From: Alison Meeus [REDACTED]
Sent: 29 March 2018 10:49
To: Planning.Responses
Cc: Jacky Pendleton
Subject: F-4-18 Ford Lane FAO: Anita Gardner

WEST SUSSEX COUNTY COUNCIL CONSULTATION

TO:	Arun District Council FAO: Anita Gardner
FROM:	Highways, WSCC
DATE:	29/03/2018
LOCATION:	Land to the South of, Ford Lane, Ford, Arundel, BN18 0DF
SUBJECT:	F/4/18/PL Salt storage building, office building, parking & turning area & open storage areas for highways maintenance depot - This is a Departure from the Development Plan.
DATE OF SITE VISIT:	n/a
RECOMMENDATION:	☐ Advice ☐ Objection ☐ Modification ☒ No Objection ☐ More Information ☐ Refusal
S106 CONTRIBUTION TOTAL:	£ n/a See below for breakdown.

Proposed Site Plan and Location Plan

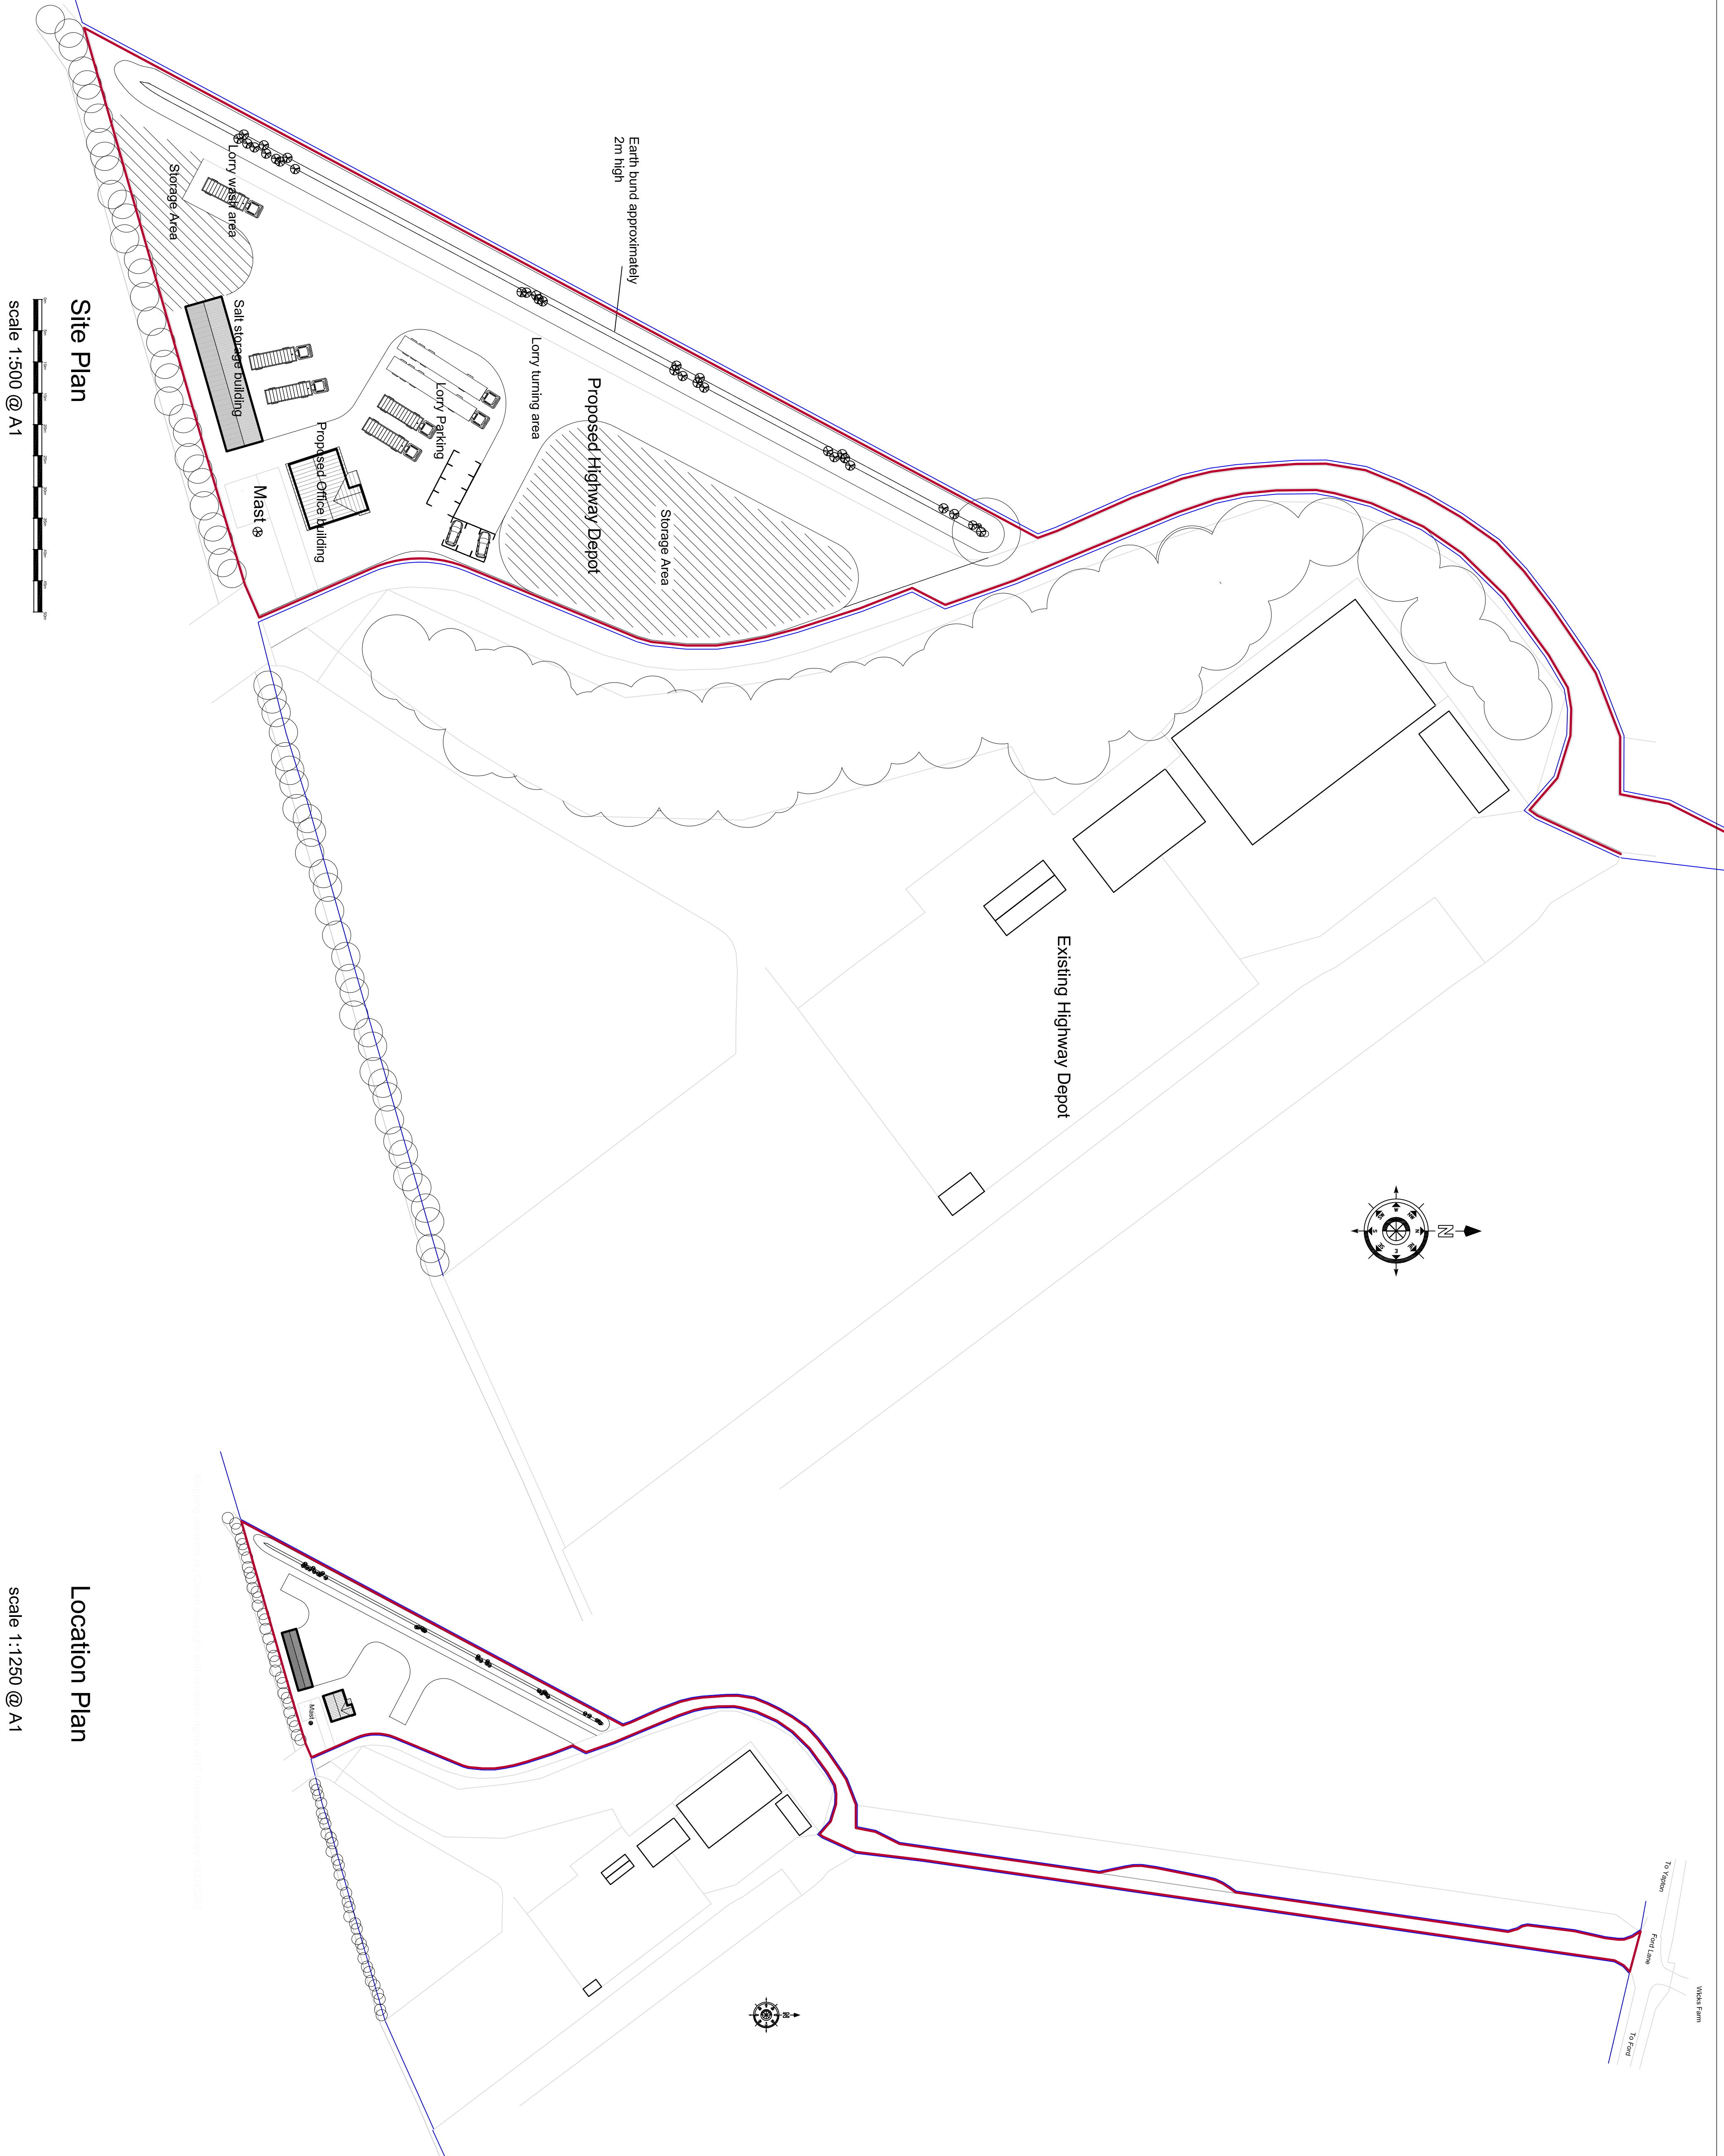
Access into the depot from the public highway is at Ford Lane. Ford Lane is a 60mph rural lane with no footways. The access provides very good visibility with no obstructions within the visibility envelope. WSCC raise no issues with the current access and would consider it suitable for the proposed use.

There will be an additional 6 employees, which could lead to an increase in vehicle moments per day however a car sharing culture is well established and the increase is so minimal no immediate issues are raised.

A plan should be submitted to the LPA as soon as possible to ensure any construction related issues have been considered and safety measures or plan implemented prior to commencement of the works.

No part of the development shall be first occupied until the car parking spaces have been constructed in accordance with plans and details submitted to and approved in writing by the Local Planning Authority. These spaces shall thereafter be retained at all times for their designated use.

No part of the development shall be first occupied until covered and secure cycle parking spaces have been provided in accordance with plans and details submitted to and approved by the Local Planning Authority.

No part of the development shall be first occupied until the vehicle parking and turning spaces have been constructed in accordance with the approved plan. These spaces shall thereafter be retained for their designated use.
